PIKE SOLAR SITE DEVELOPMENT PLAN

PCD-ENGINEERING REVIEW COMMENTS
IN BLUE BOXES WITH BLUE TEXT

PIKE SOLAR PROJECT

G001

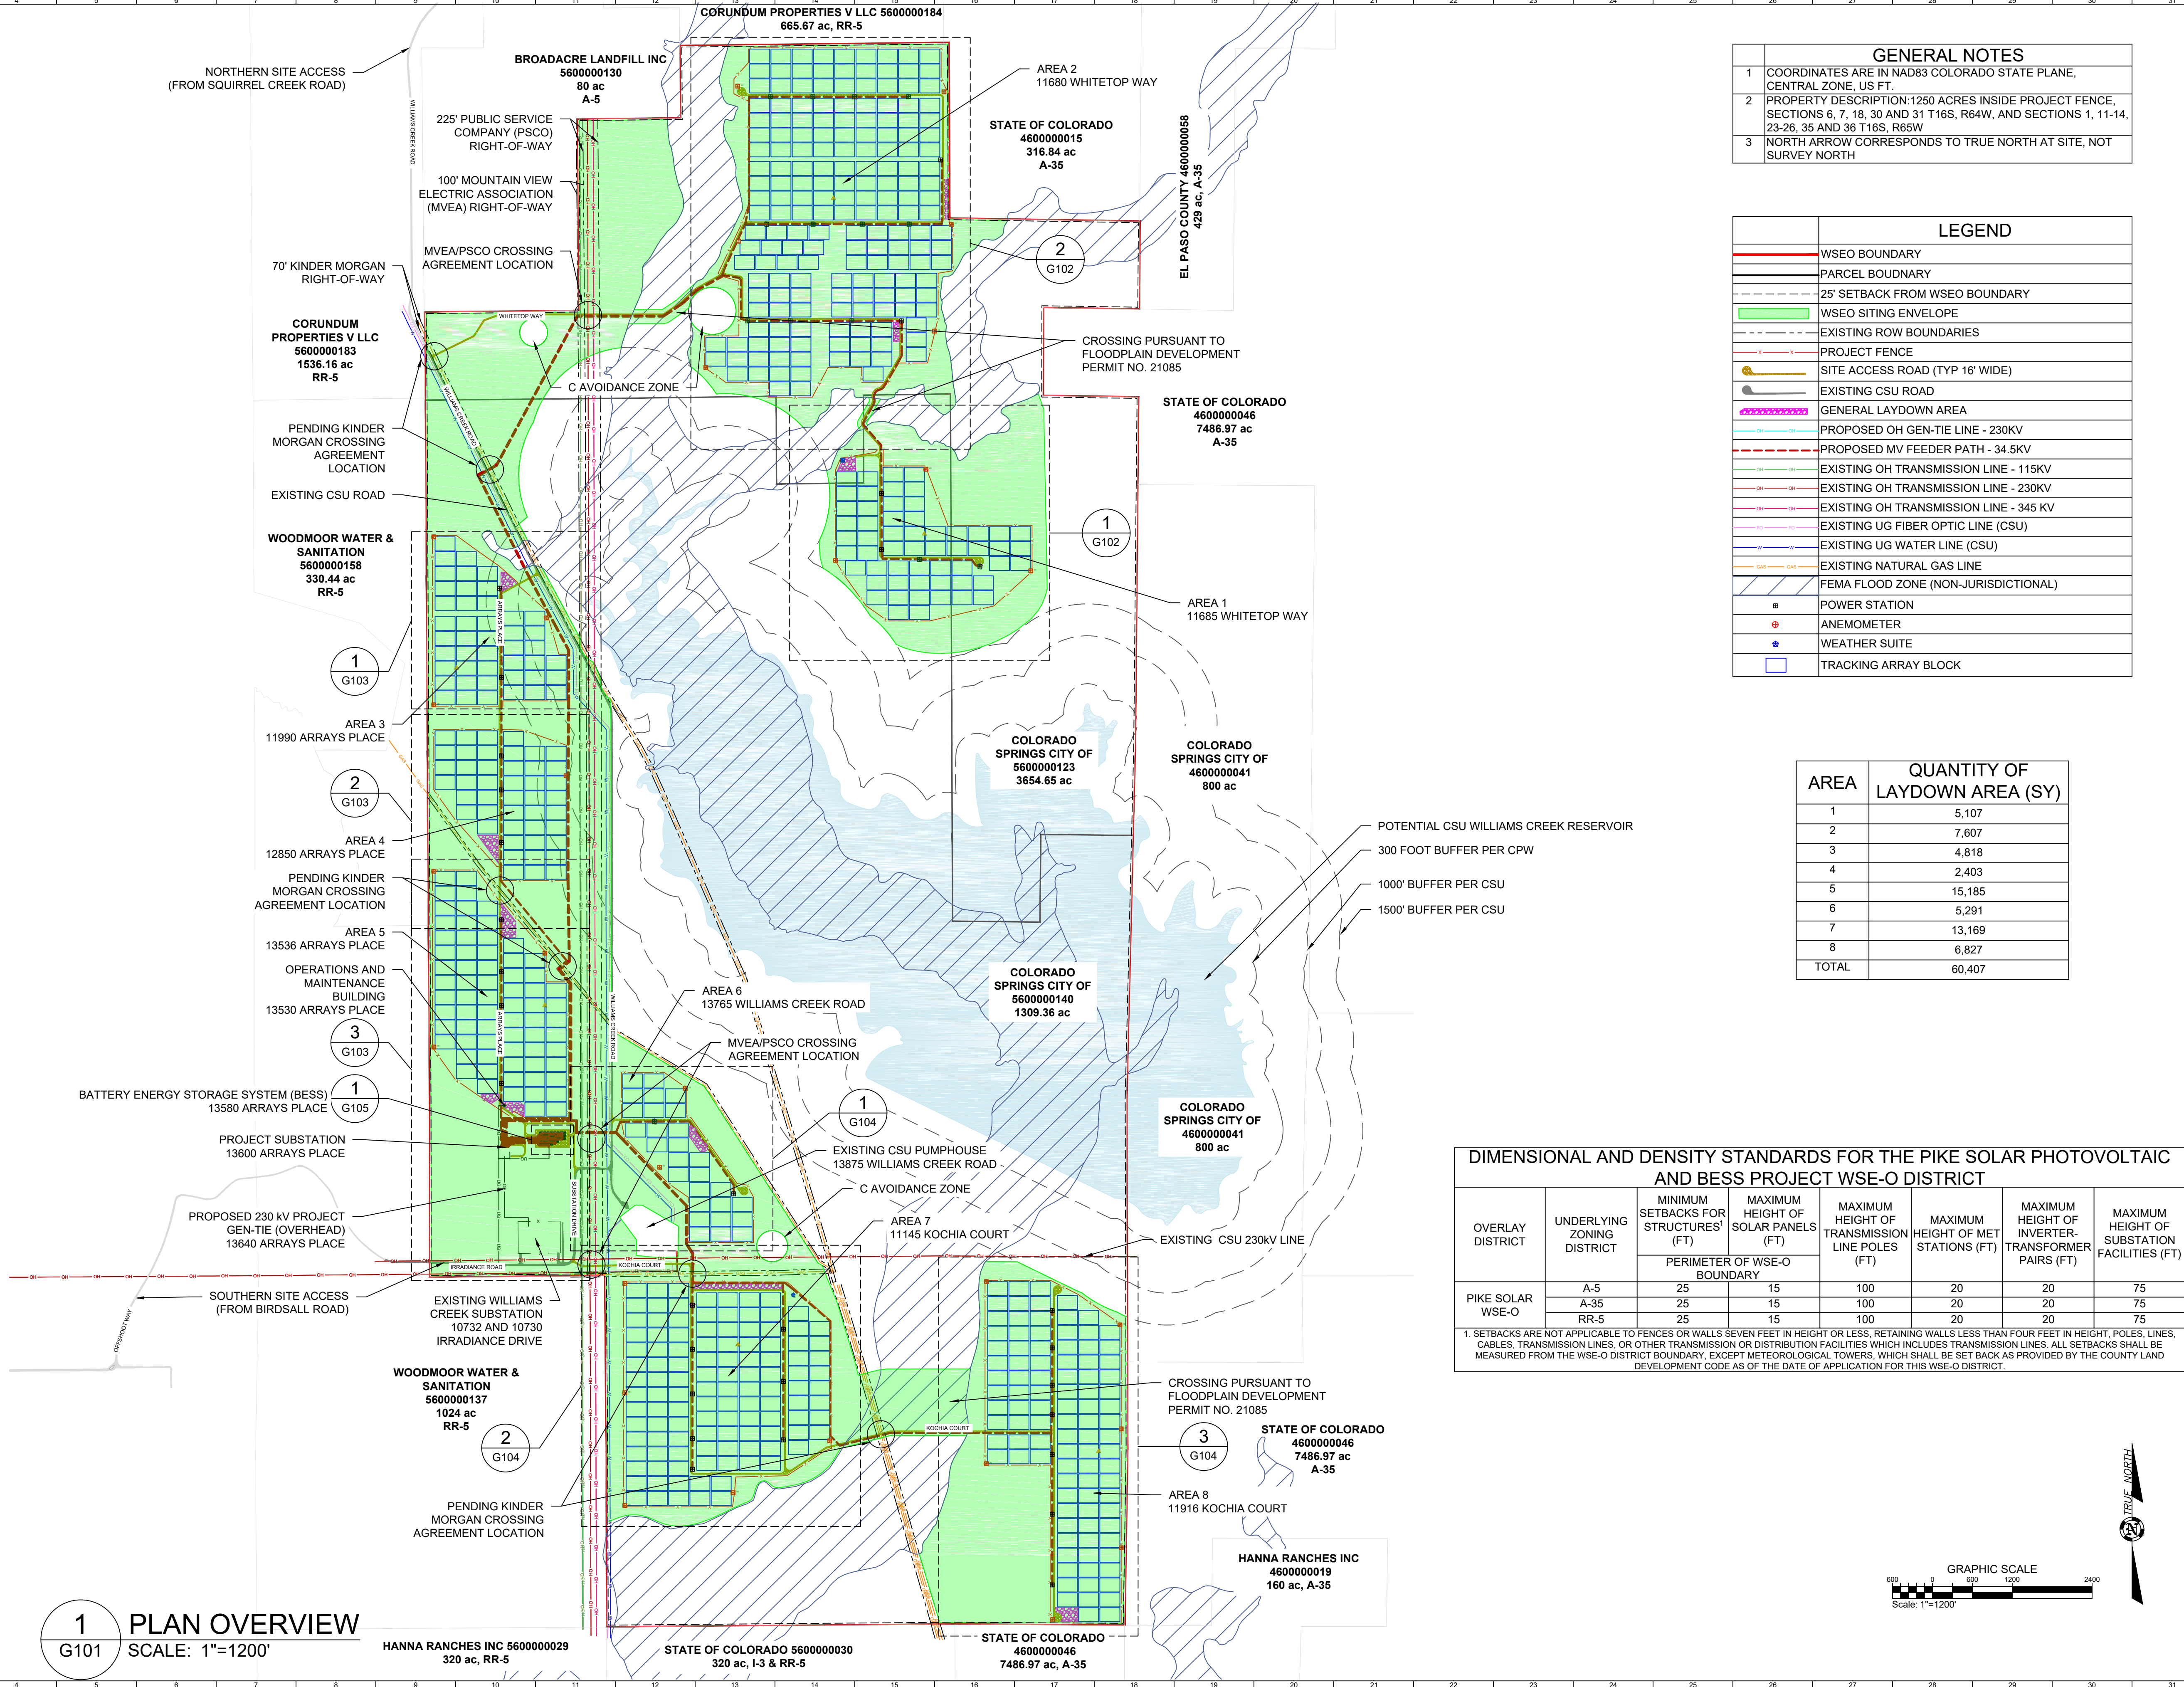
Add: " Haul Routes are to be followed based upon the approved haul route plan placed in PCD file no. PPR22-8; (No hauling or deliveries is allowed on Sundays during construction of the project, nor the Hanover Festival days.

Add project number
here or in a title block

G101
GENERAL SITE PLAN - SITE OVERVIEW

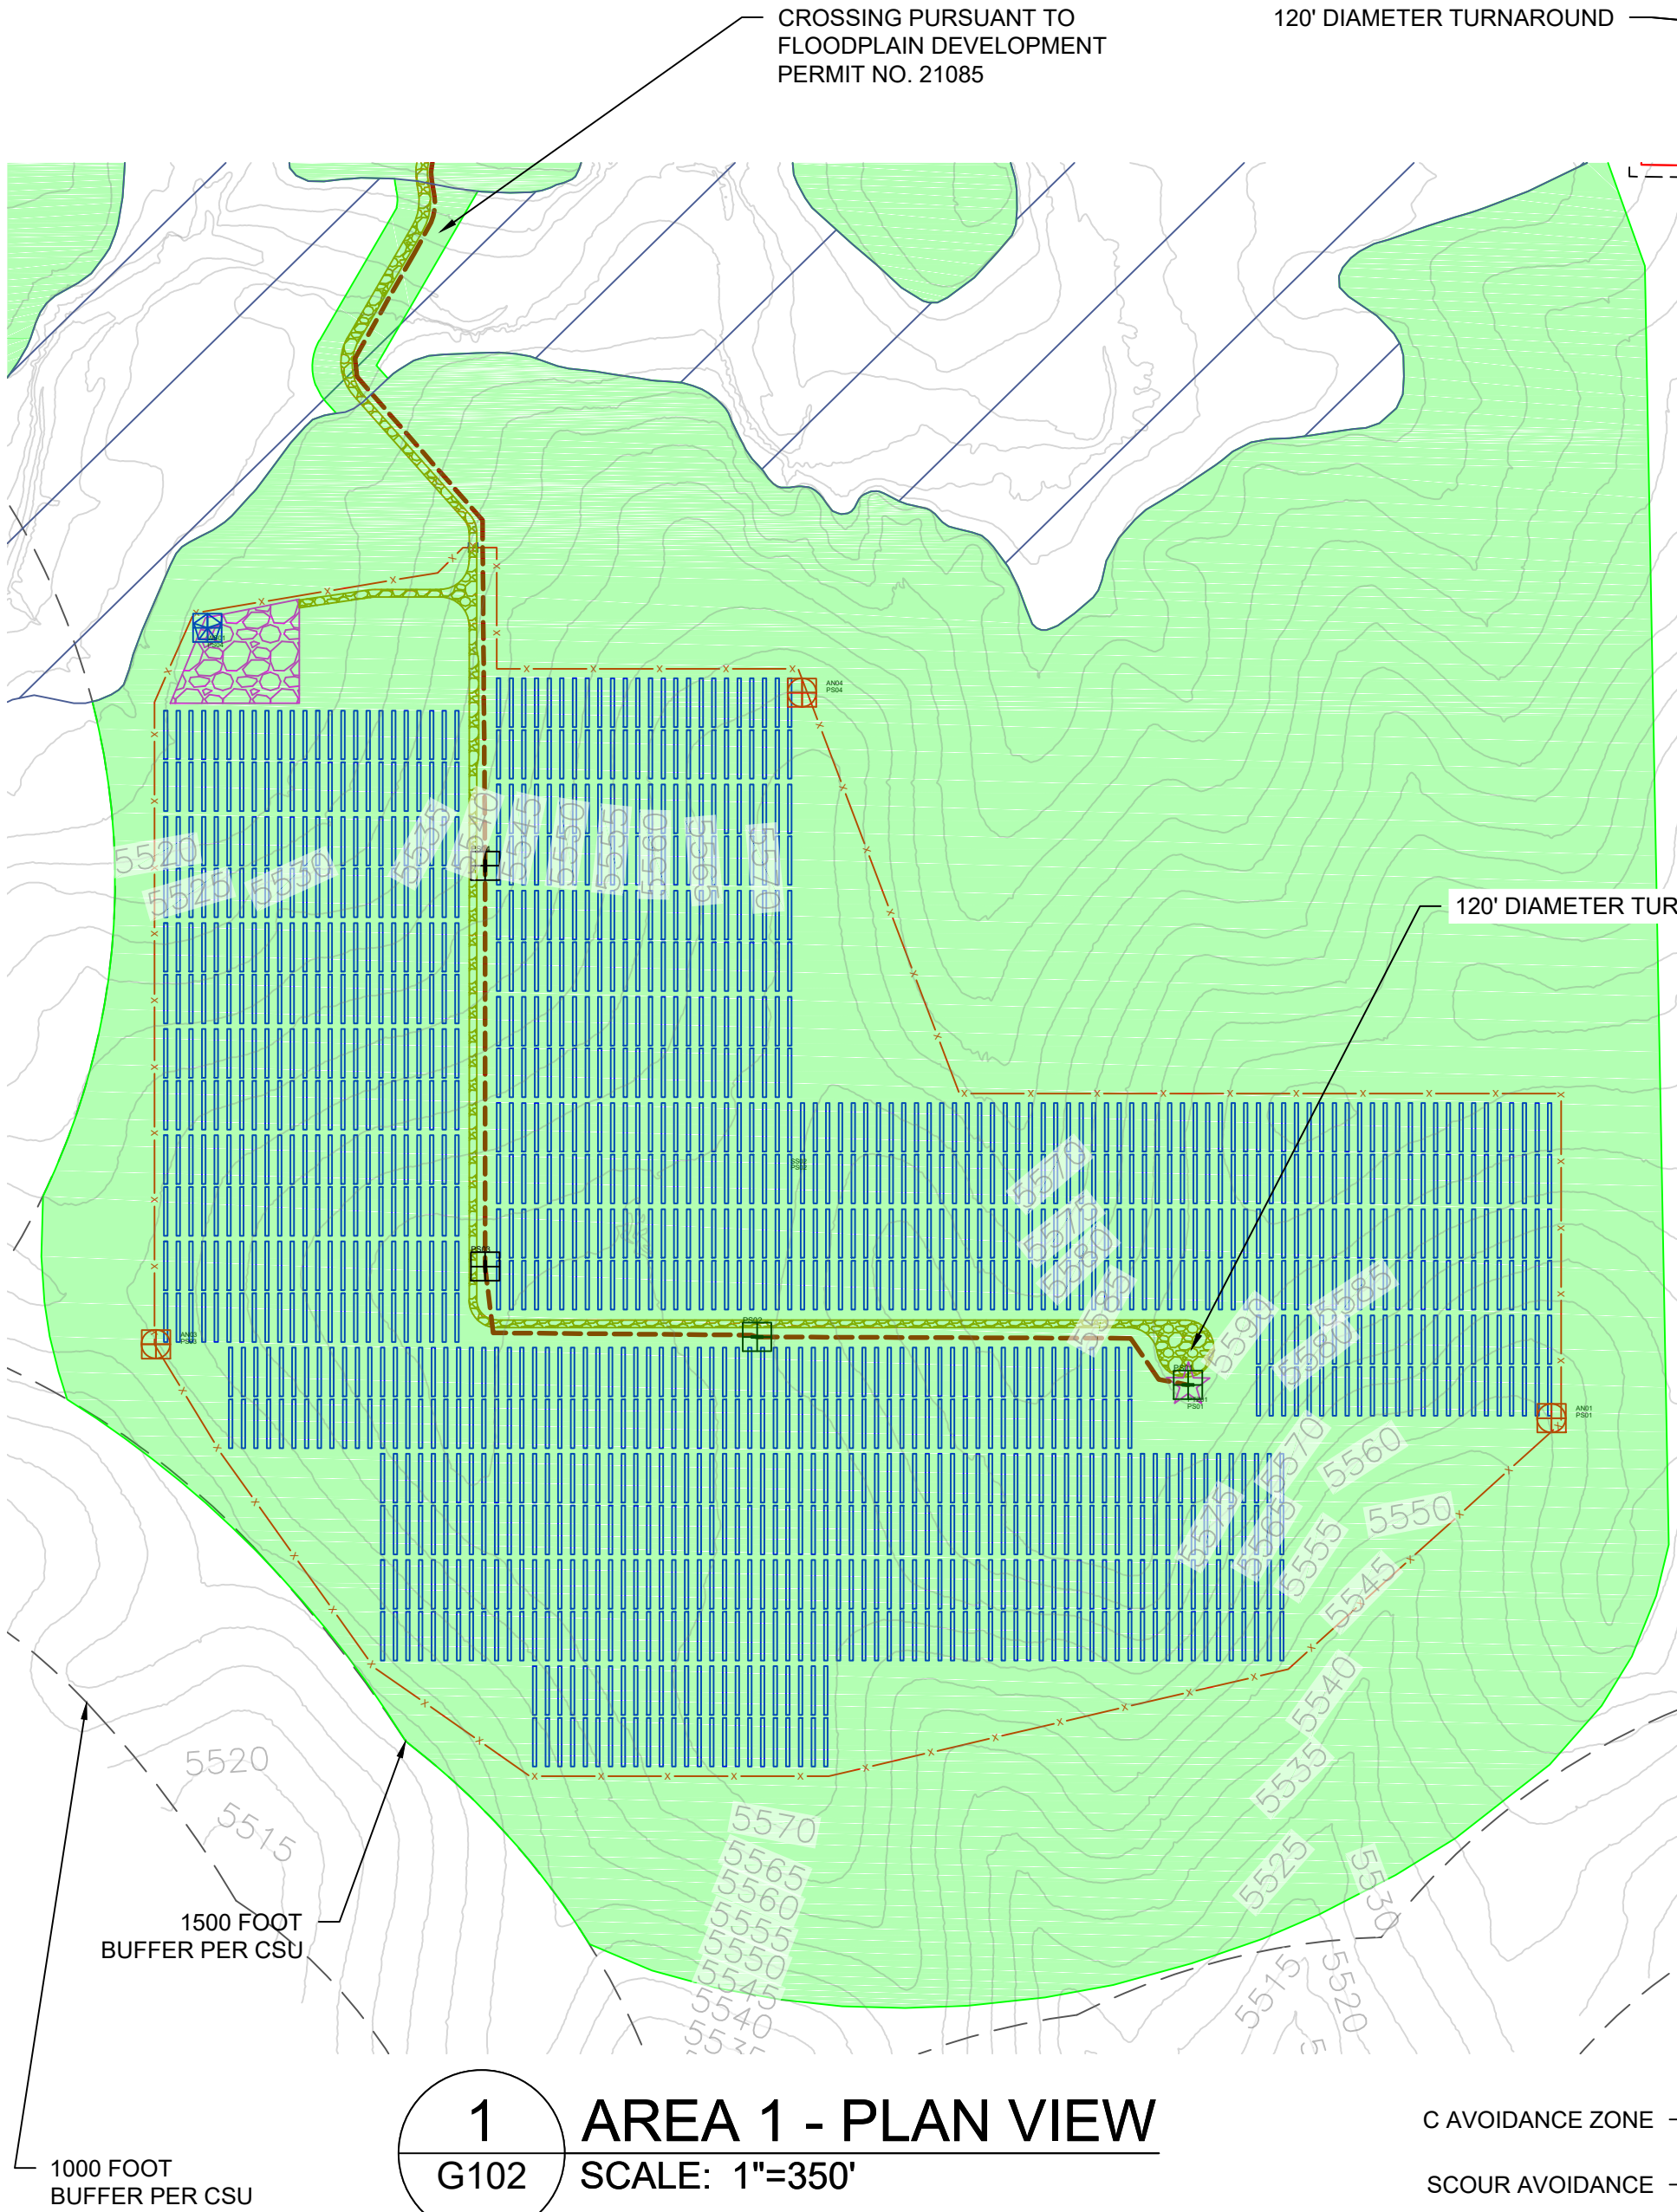
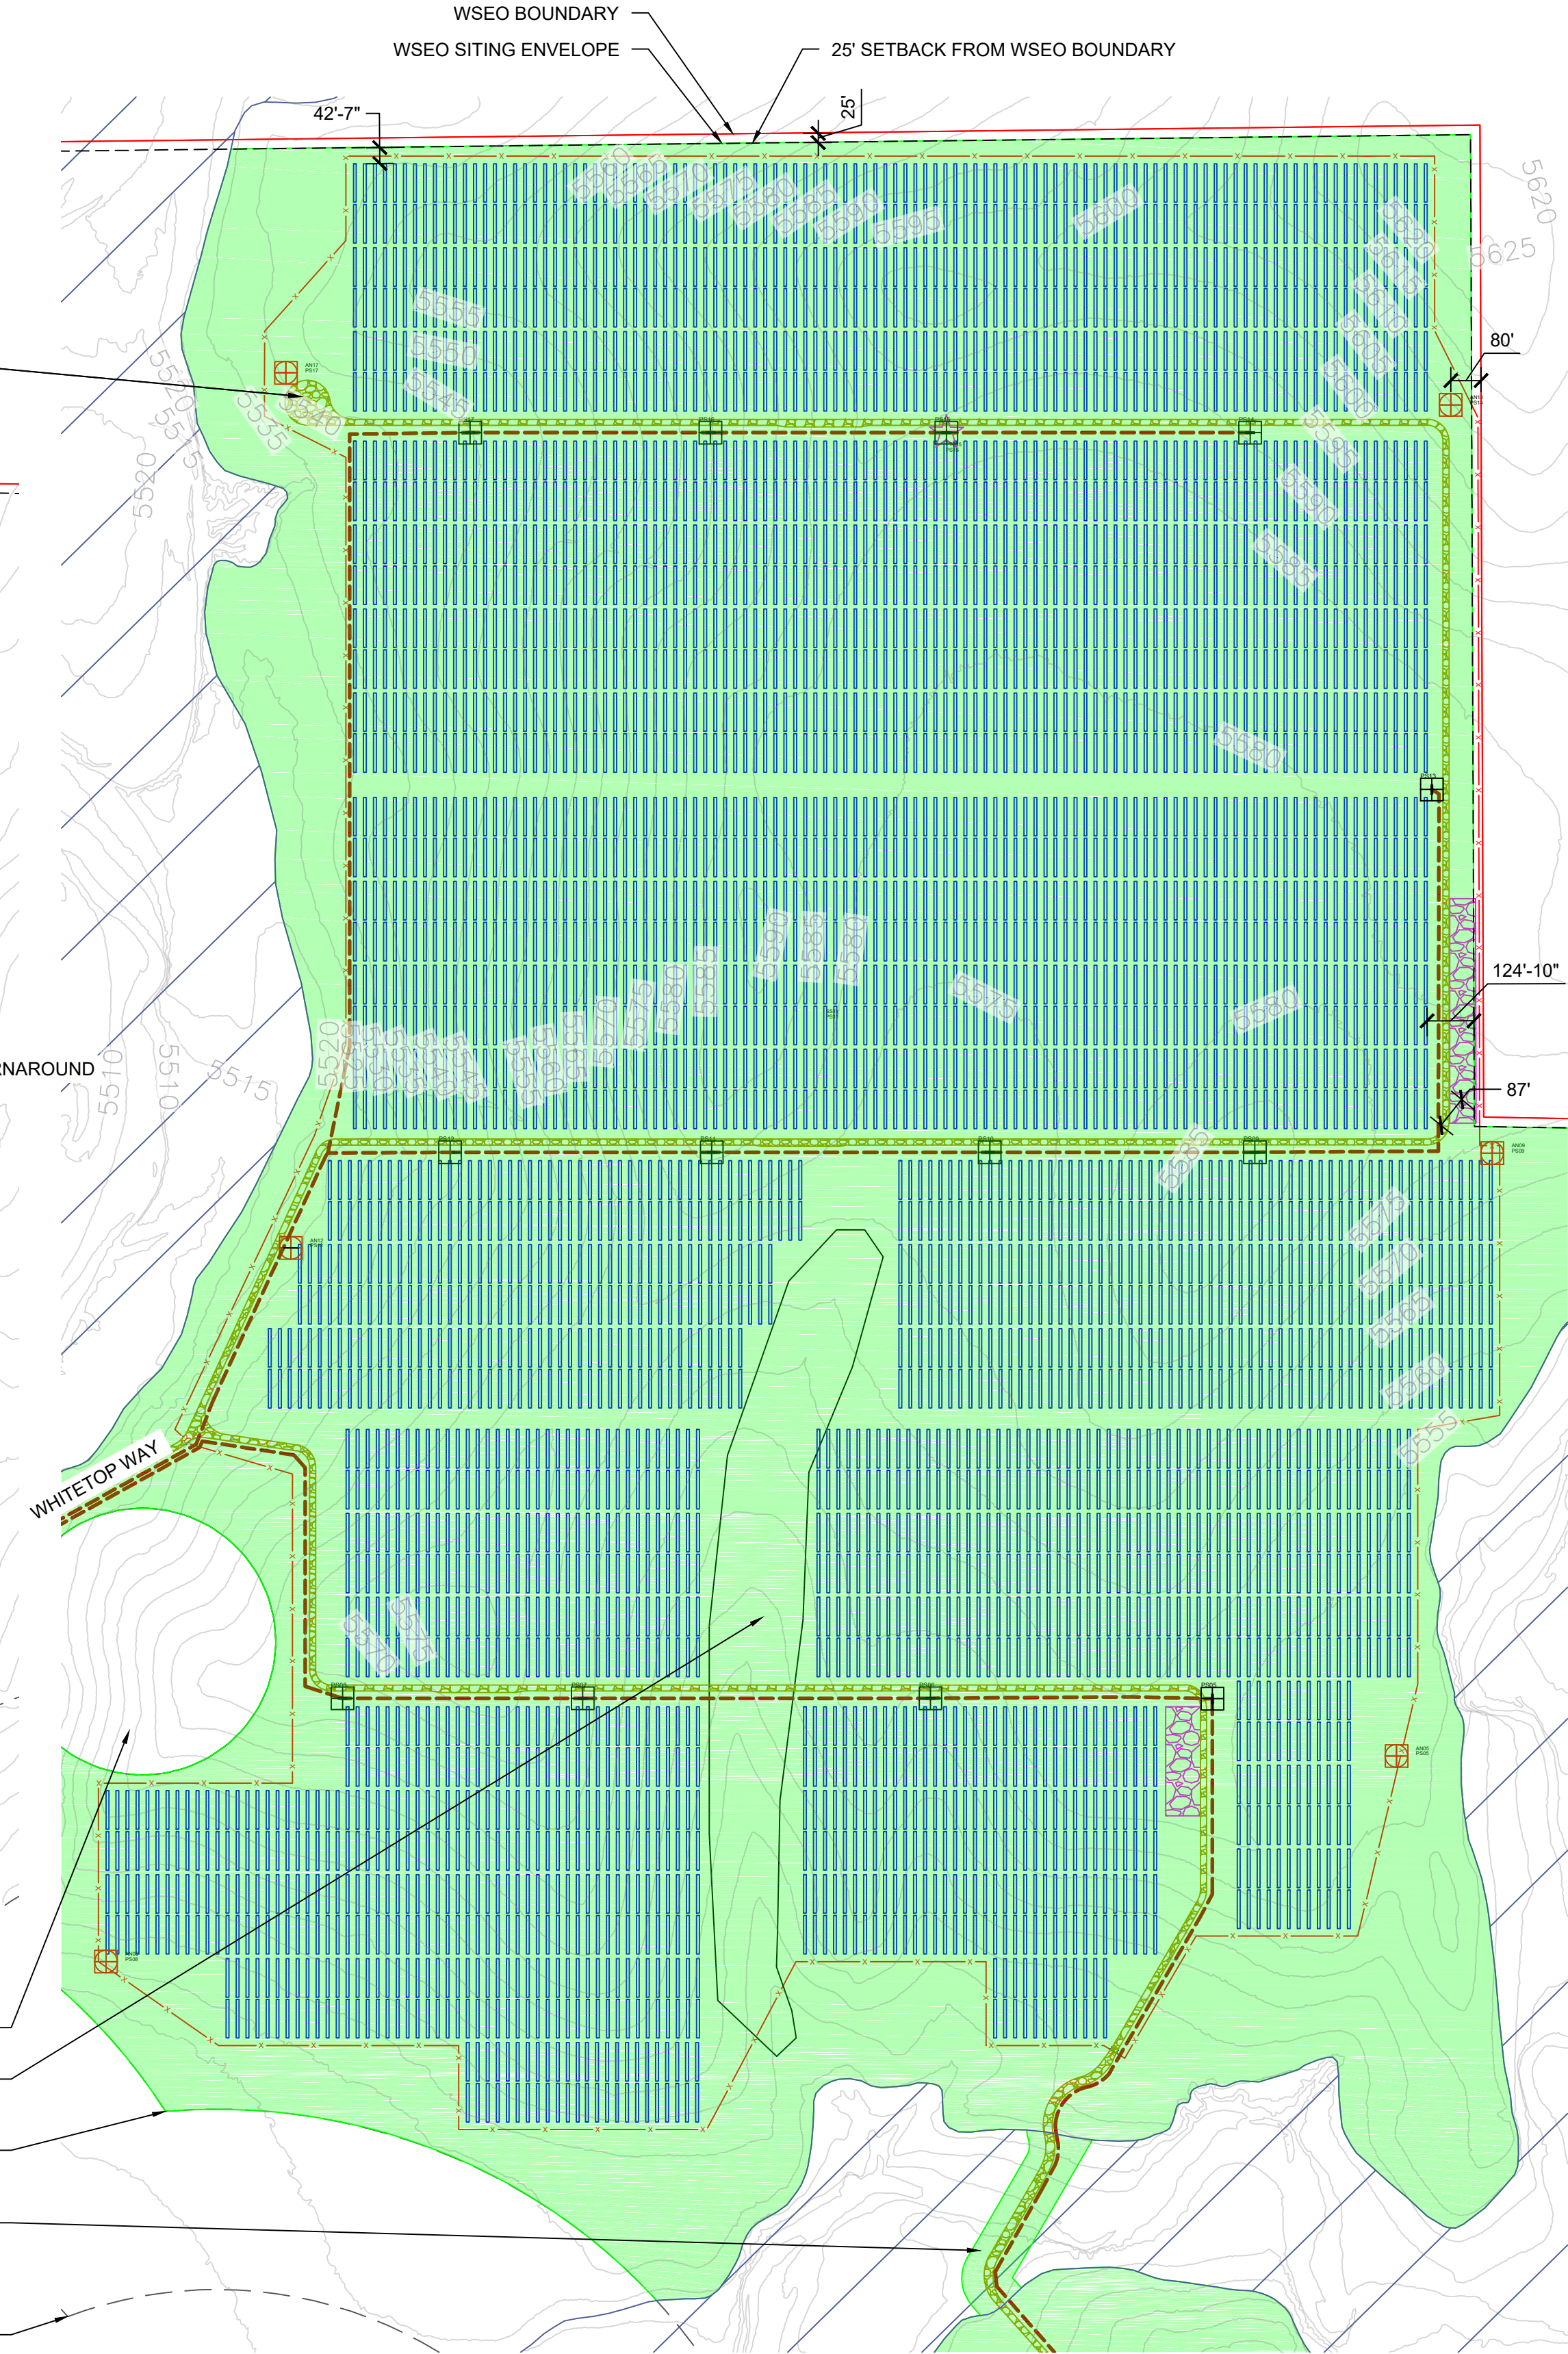
add private under all private road names all sheets.

is this the wildlife exclusionary fence or security fence?
Provide detail if security, label which fence, add both symbols to all general plan sheets

O and M building, BES storage bldg sl add to legend all sheets, add buildings ; add building details SF and dimensions to general site plan sheets

label these as gravel or natural drive isles and label width of them all sheets
